CITY OF ALBUQUERQUE

Planning Department Transportation Development Services

December 16, 2015

**Re: AIS Retail
12th St., Indian School Rd. and Menaul
15-Day Temporary Certificate of Occupancy- Transportation Development
Engineer's/Architect's Stamp dated 8-24-15 (H13-D106)
Certification dated 12-03-15**

C1 NEW SIGNAGE AT CORNER
 SCALE: 1/2" = 1' - 0"

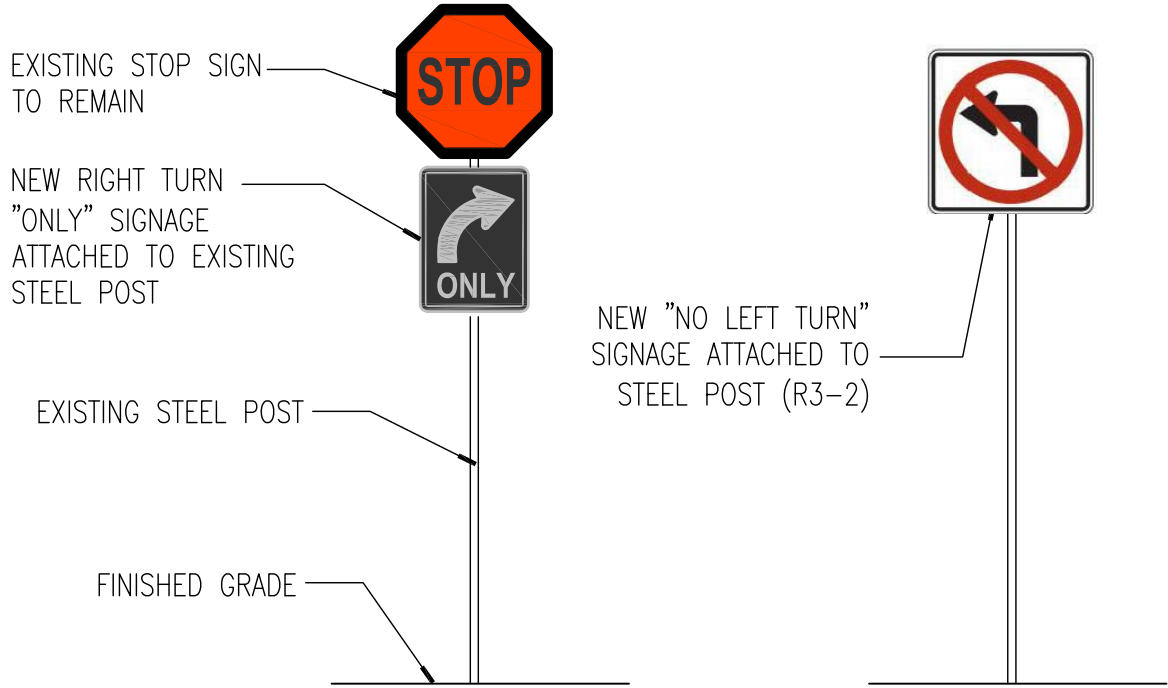
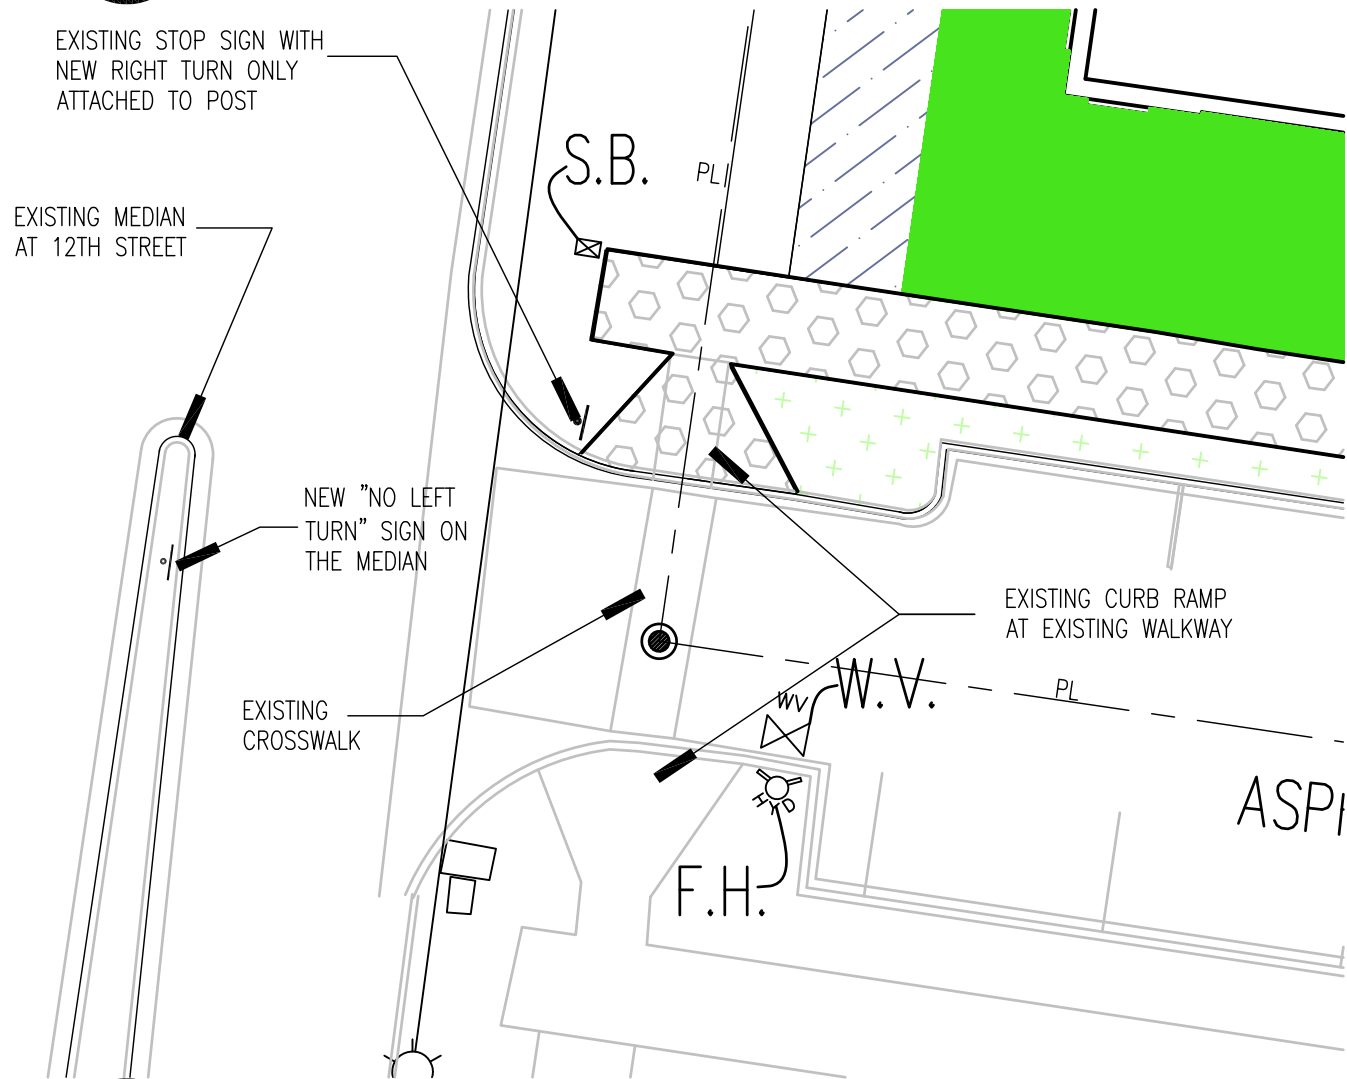
- Please provide proof of approved additional signage to restrict access prior to the release of permanent CO.
